**WEST SUSSEX COUNTY COUNCIL
STRATEGIC PLANNING CONSULTATION**

SUBJECT: BE/23/14/PL

**Change of use from Class B8 (Storage or Distribution) to Class A1 (Shops)
including partial demolition.**

**Adjacent warehouse site to McDonalds, Oldlands Way, Bersted, West Sussex,
PO22 9SA**

Site Plan as Proposed

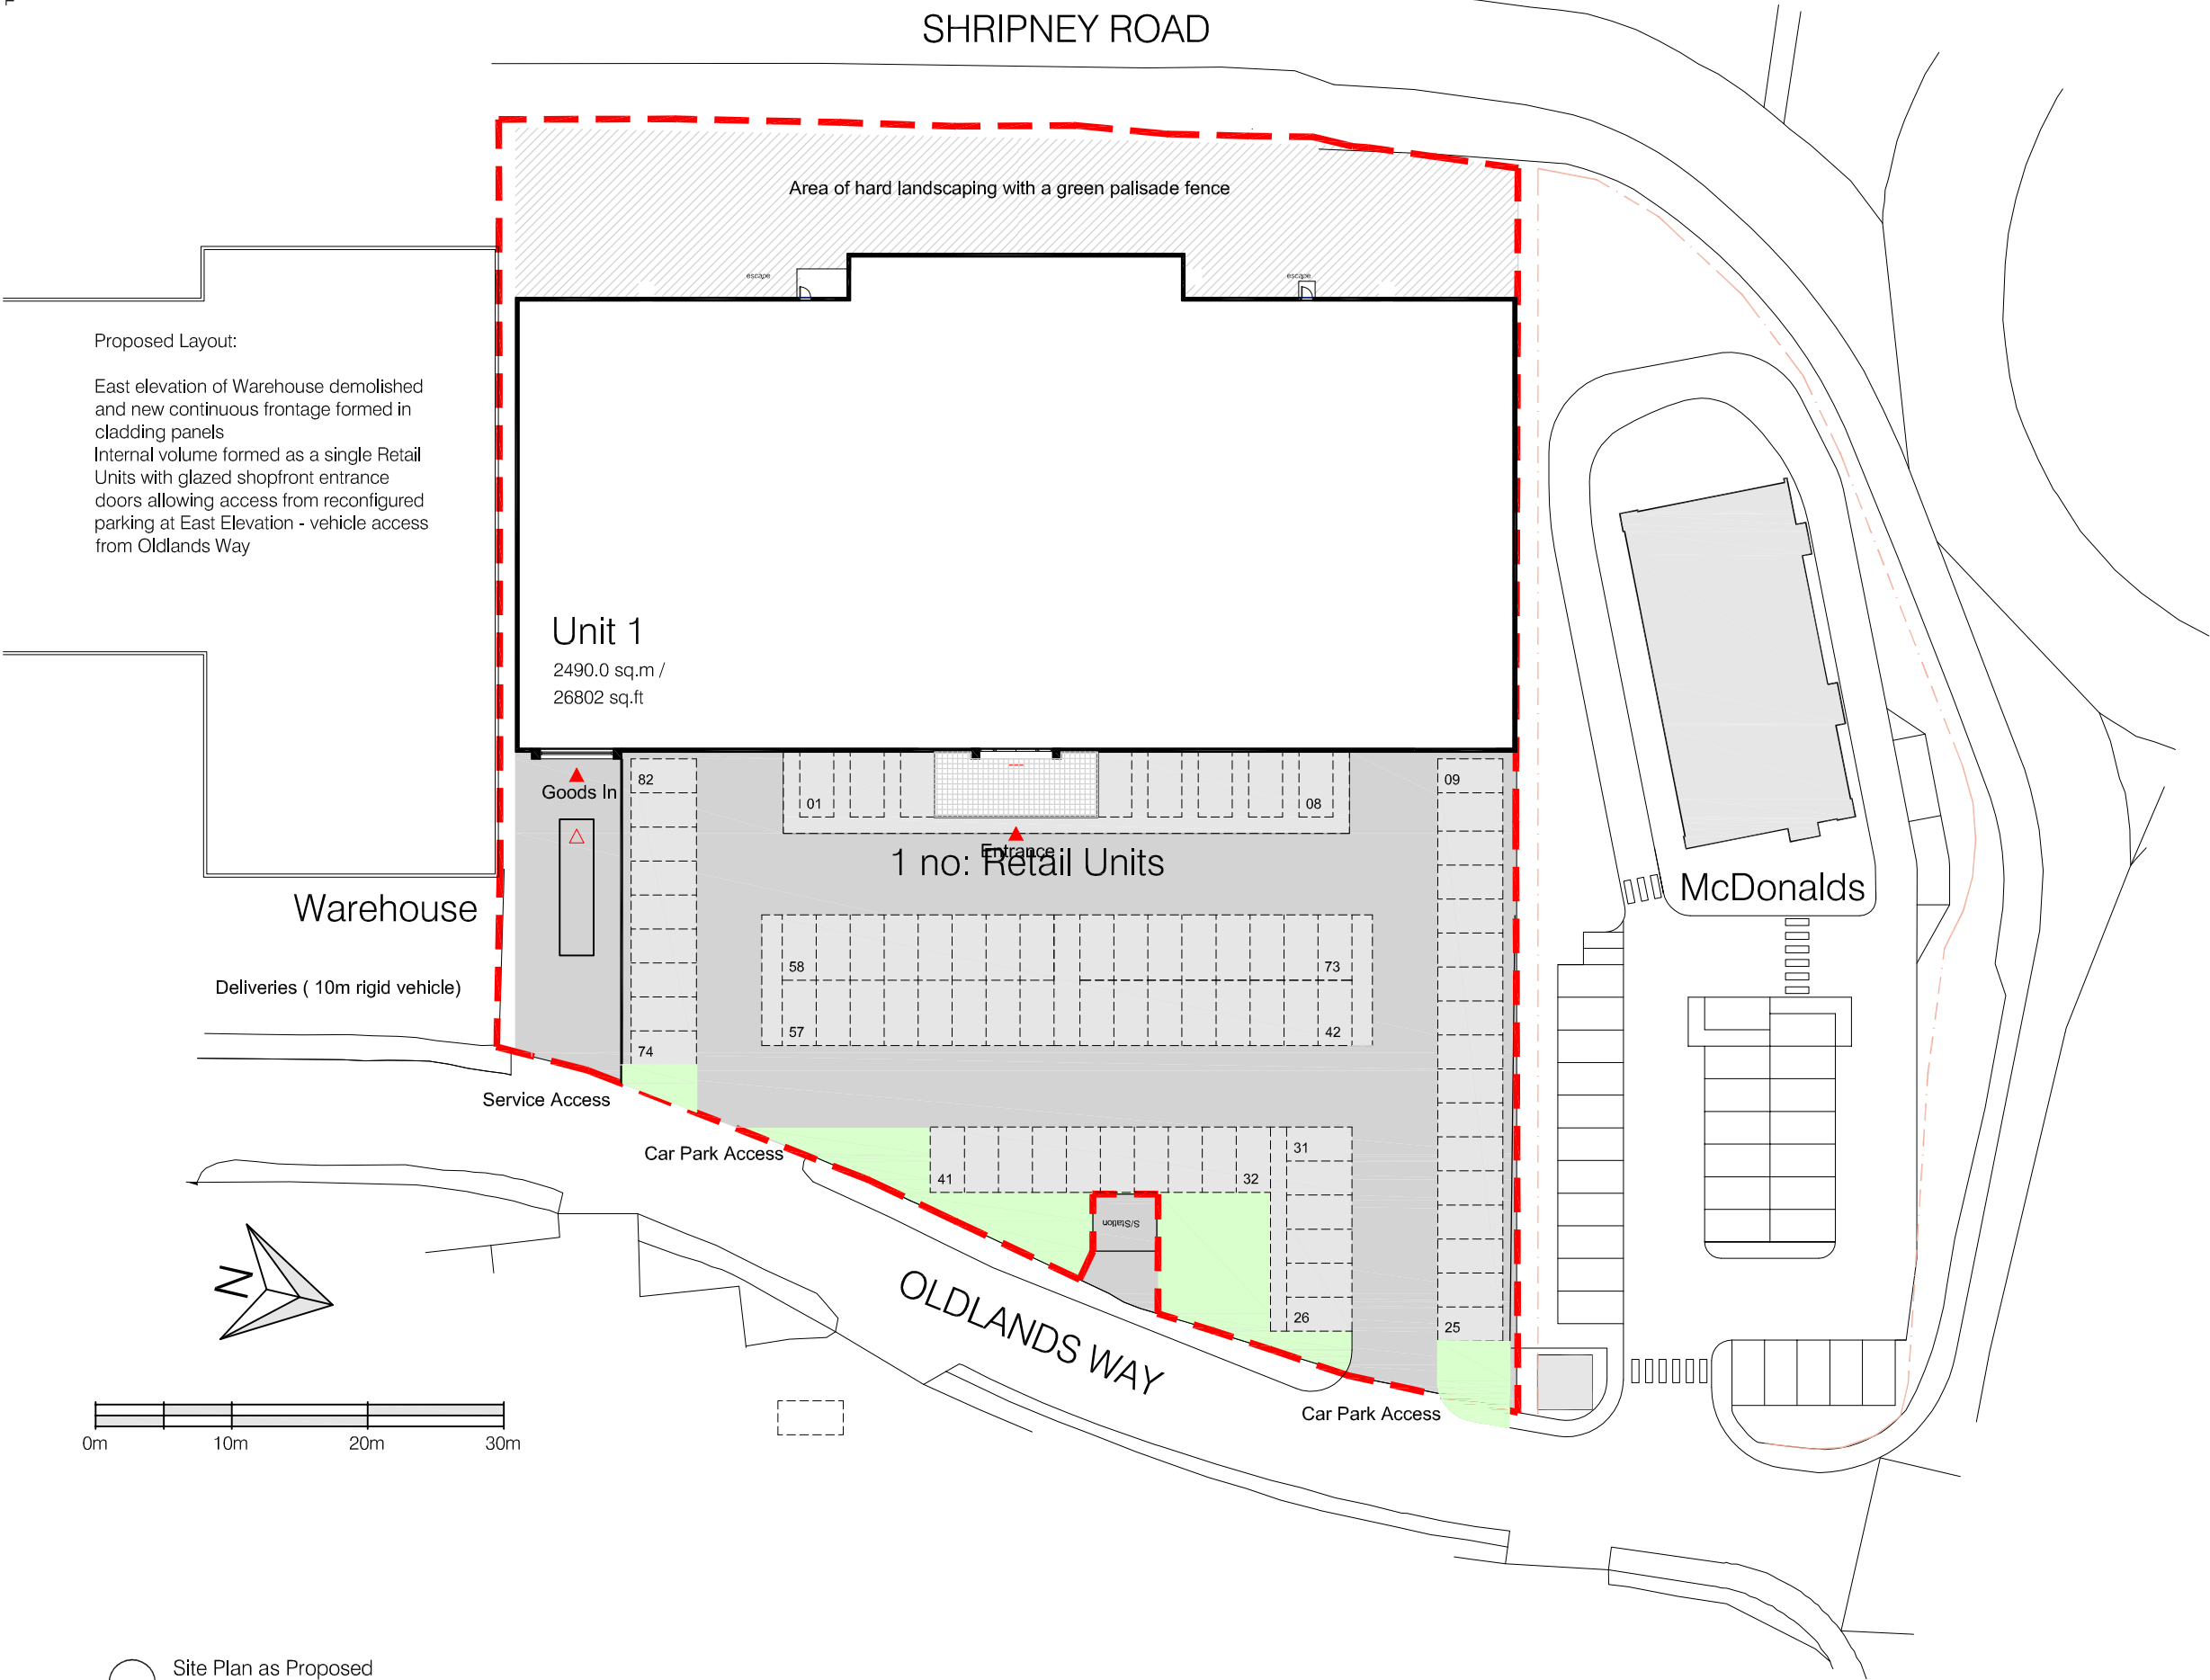
The proposals include revised access arrangements; while there appears to be a good level of visibility, splay should be provided on the access plans from a setback of 2.4m and in accordance with Manual for Streets guidance within either land owned by the Applicant or within the highway boundary.

The location of parking in the proximity of the access could result in the vehicles exiting the spaces coming into conflict with vehicles accessing the site, or result in Oldlands Way becoming obstructed unexpectedly while vehicles wait for the vehicles exiting the space.

The plans do not appear to indicate a route for pedestrians from Oldlands Way, who would instead be expected to share the internal car park roads. Provision should be made to provide a dedicated provision to encourage the use of sustainable modes. In addition, there appears to be no provision to encourage cycle journeys such as sheltered and secure parking.
